City of Portland, Maine - Building or Use Permit Application

Location of Construction: 95 GRAY ST	Owner Name: GRAY STREET LLC	Owner Address: 4 MILK ST STE 103	Phone:
Business Name:	Contractor Name: property owner	Contractor Address:	Phone:
Lessee/Buyer's Name	Phone:	Permit Type: Additions - Multi Family	Zone:

Past Use: 3 Unit Building	Proposed Use: 3 Unit Building - install new handrail balustrade on existing front steps	Permit Fee:	Cost of Work: \$0.00	CEO District: 2
Proposed Project Description: install new handrail balustrade on existing front steps		FIRE DEPT: <input type="checkbox"/> Approved <input type="checkbox"/> Denied	INSPECTION: Use Group: Type:	
		Signature:	Signature:	
PEDESTRIAN ACTIVITIES DISTRICT (P.A.D.)				
Action: <input type="checkbox"/> Approved <input type="checkbox"/> Approved w/Conditions <input type="checkbox"/> Denied				
		Signature:	Date:

Dept: Historic **Status:** Approved with Conditions **Reviewer:** Deborah Andrews **Approval Date:** 04/13/2010

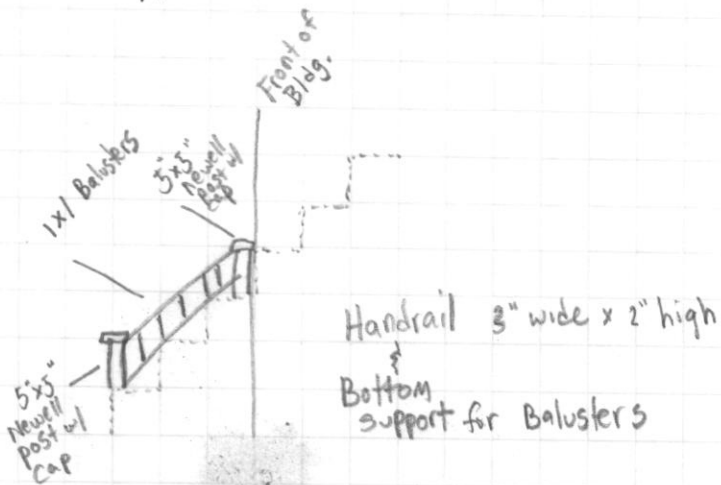
1) * Balusters to be built from 2" x 2" stock (finished size is 1 1/2" x 1 1/2"). Spacing between balusters not to exceed 3 1/2".
